Subject: RE: Saltbox Unit 9 site Planning Condition 12 response Surface water

Paul Cann
Principal Drainage Engineer
Engineering Services

Please see attached revised drainage proposals for the Saltbox Unit 9 project for the release of planning condition 12. The proposals have been amended to lift the drainage system up to achieve a gravity discharge as per the original strategy. We have included on the drainage plan drawing pipe sizes, gradients, cover and invert levels also added to the drawing as requested.

C	5.04.22	MR	Add Inlet Connections
B	17.03.22	MR	Amend Overlay View
A	4.03.22	MR	Amend Layout & Volume
-	19.01.22	MR	Sales Drawing

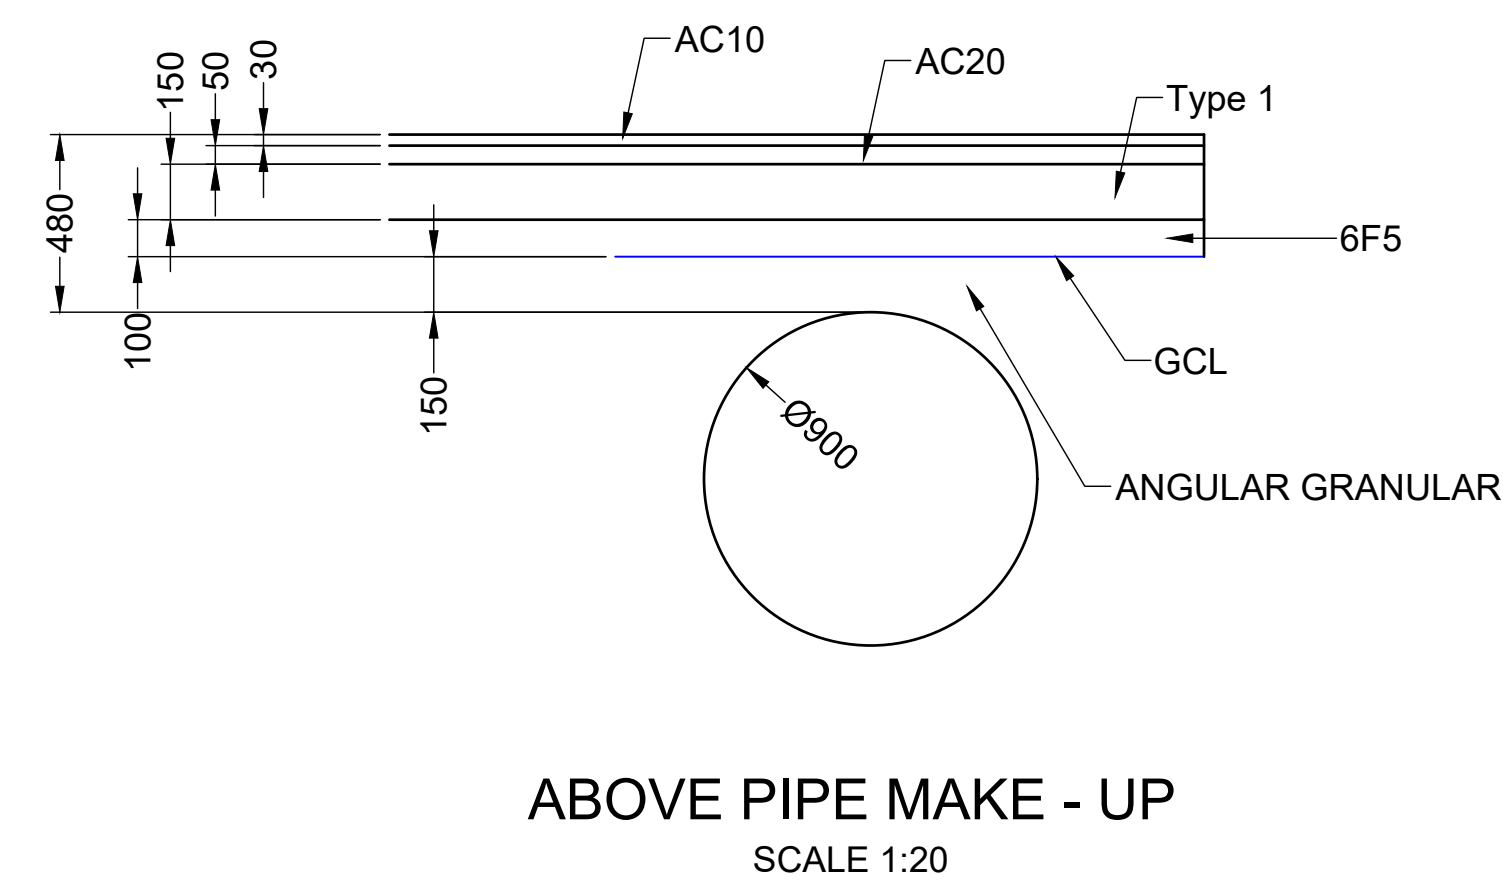
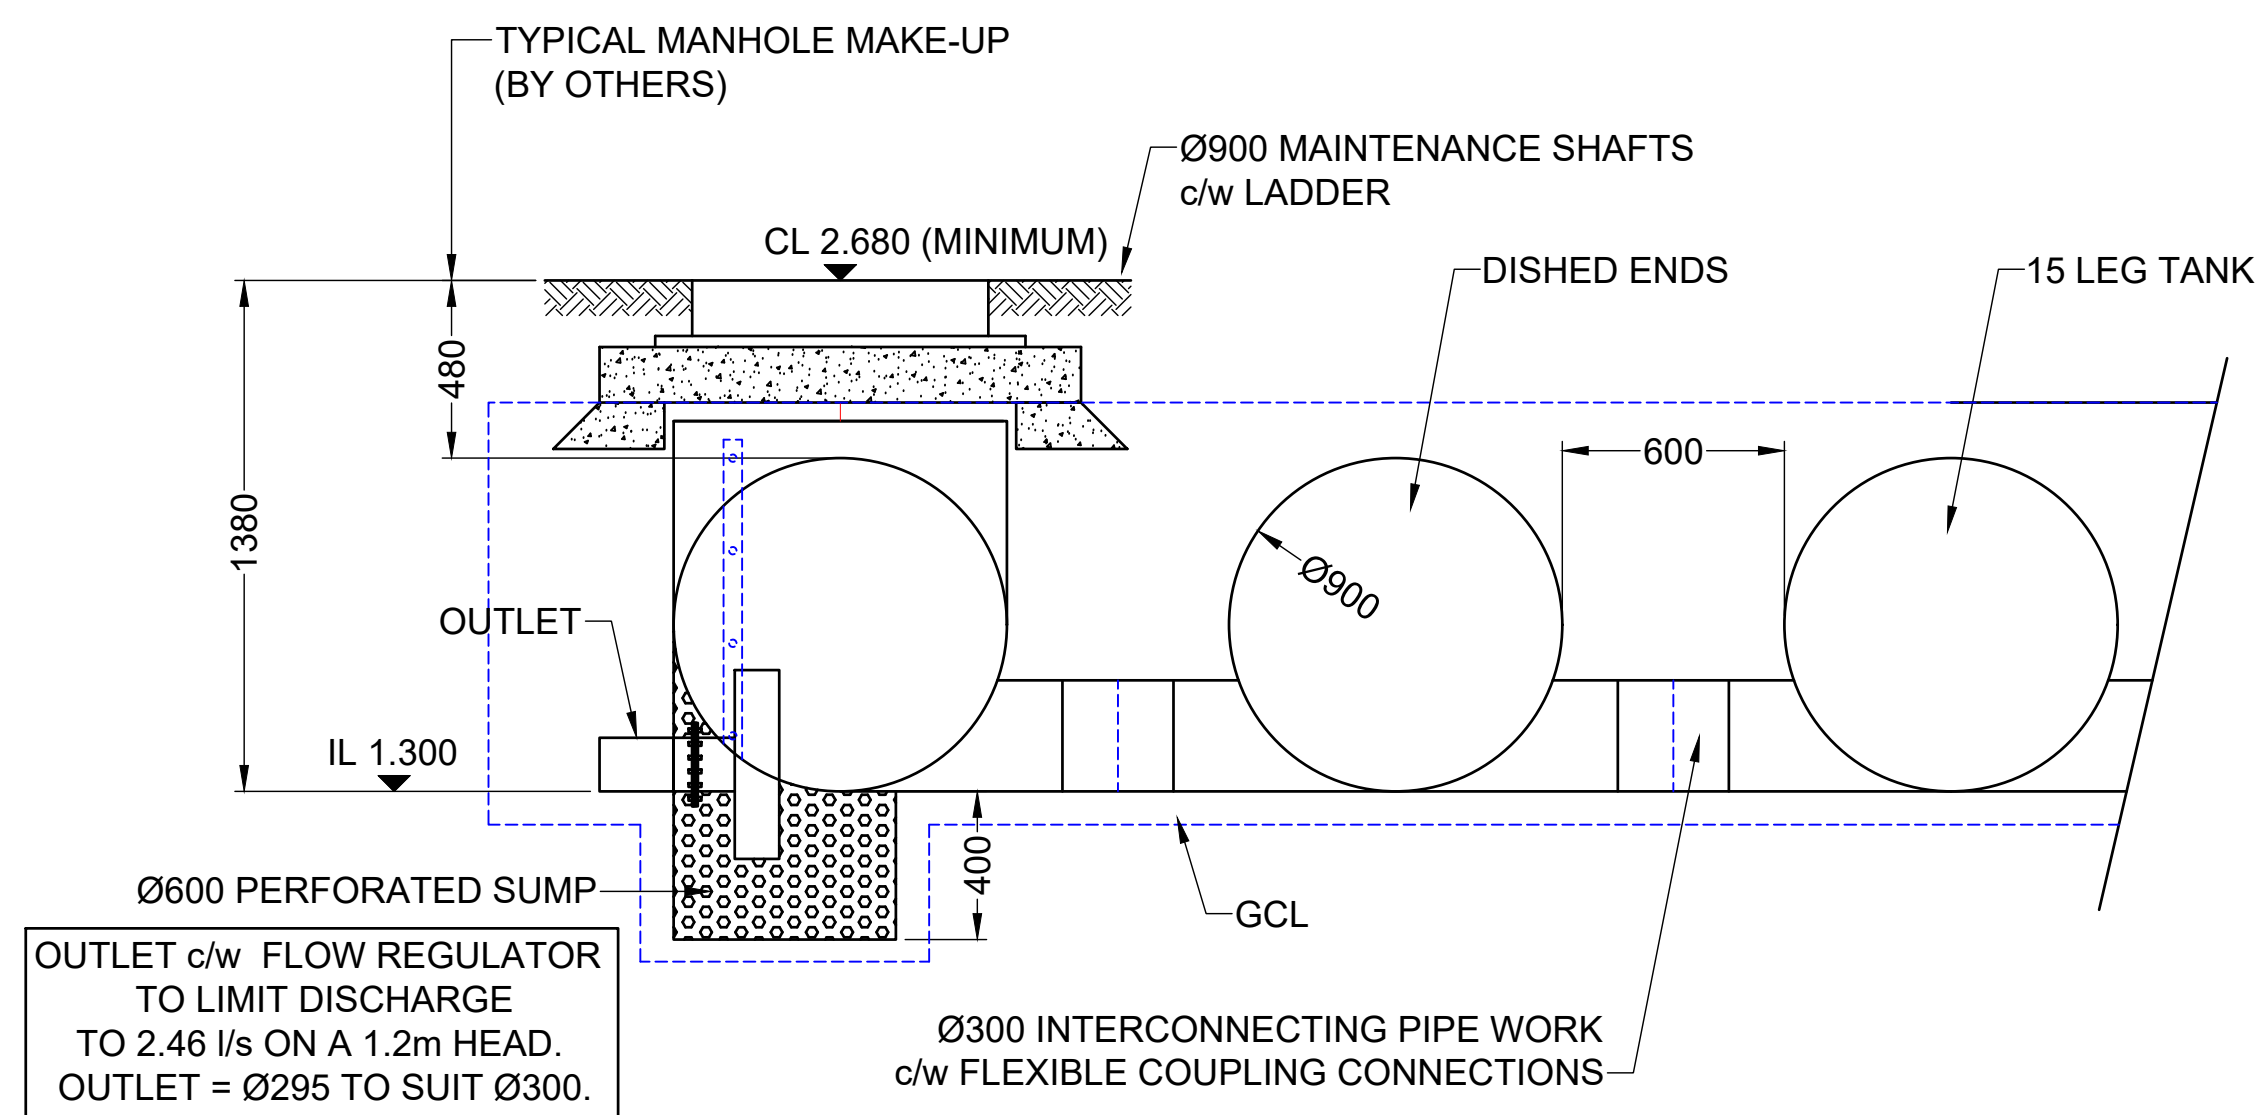
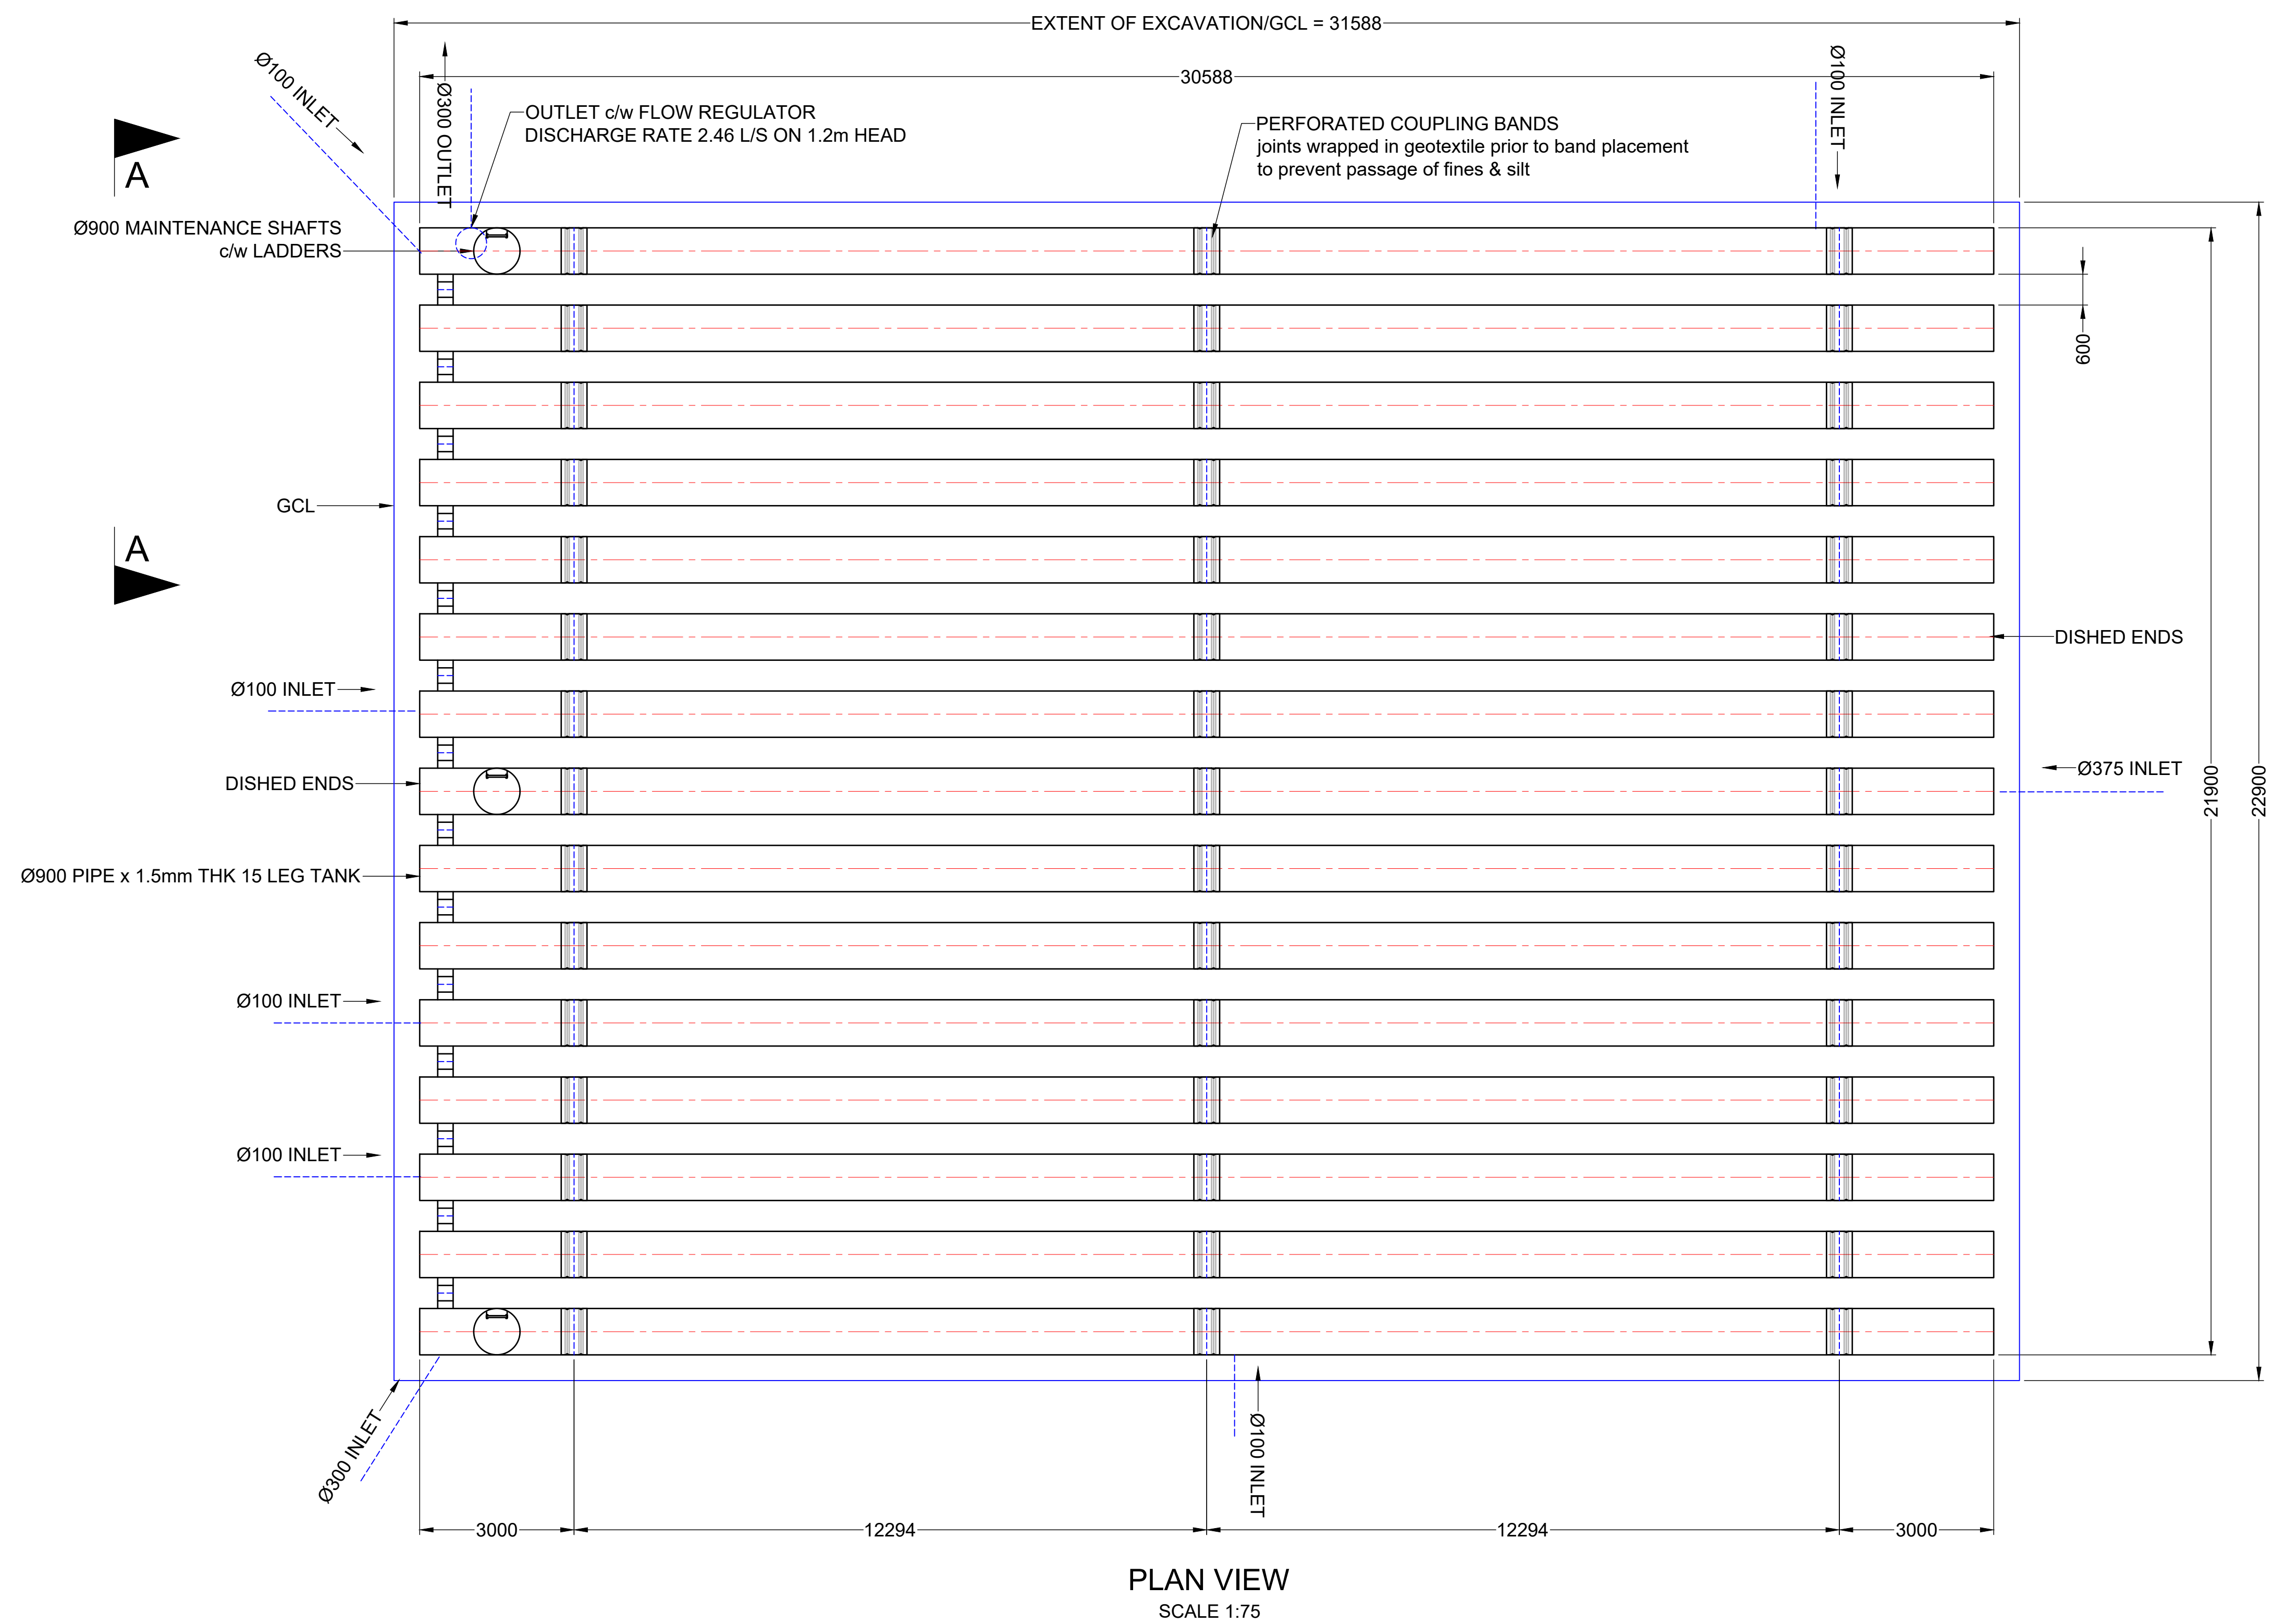
6. **Gully connection into manhole S22 – reconfigure to improve angle of connection into manhole.** We have added a 45-degree bend for straight connection into the attenuation tank. Layout plan not amended +

Tubosider plan to be adjusted. Plans adjusted to reflect original response. Ok The Tubosider drg has been partially updated. Please adjust the plan view (scale 1:75)

8. **Provide fully detailed construction details for Tubosider attenuation tank including integral chambers/flow control chamber.** Tubosider details attached. Your layout plan indicates 4 no. access chambers whilst theirs has 3 no. Clearly indicate 300mm diameter link pipe locations on layout plan. Fully detail make up above the prefabricated access chambers ie. class D400 covers, engineering brickwork, concrete slab spec & dims, etc. Include ladder access as a requirement rather than an option. Not sure why the hydrobrake sump is perforated, please advise/provide more detail. Please adjust detail to suit the 300mm outfall pipe discussed in item 17. Access chambers revised to 3 as per Tubosider detail and link pipes indicated on plan. Drawing 0500 now contains a detail of the makeup to ground level above the Tubosider shafts and ladder requirement added. Tubosider have advised us that the perforated sump is required to ensure the bottom layer of granular surround is drained through the sump. Ok but please adjust the manhole type on the manhole schedule drawing.

28. Remove wavin aquacell attenuation tank construction details as no longer relevant, including note 24 on construction detail drawings.
29. Provide fully detailed construction details for Tubosider attenuation tank including integral chambers/flow control chamber.

Please see attached amended manhole schedule drawing and Tubosider detail drawing to address comments 6 and 8 as requested.

We are aware that the Tubosider detail attached contains a plan with the previous layout as a background – we are in the process of getting this drawing updated by Tubosider with the new attached layout and will forward on as soon as we receive.
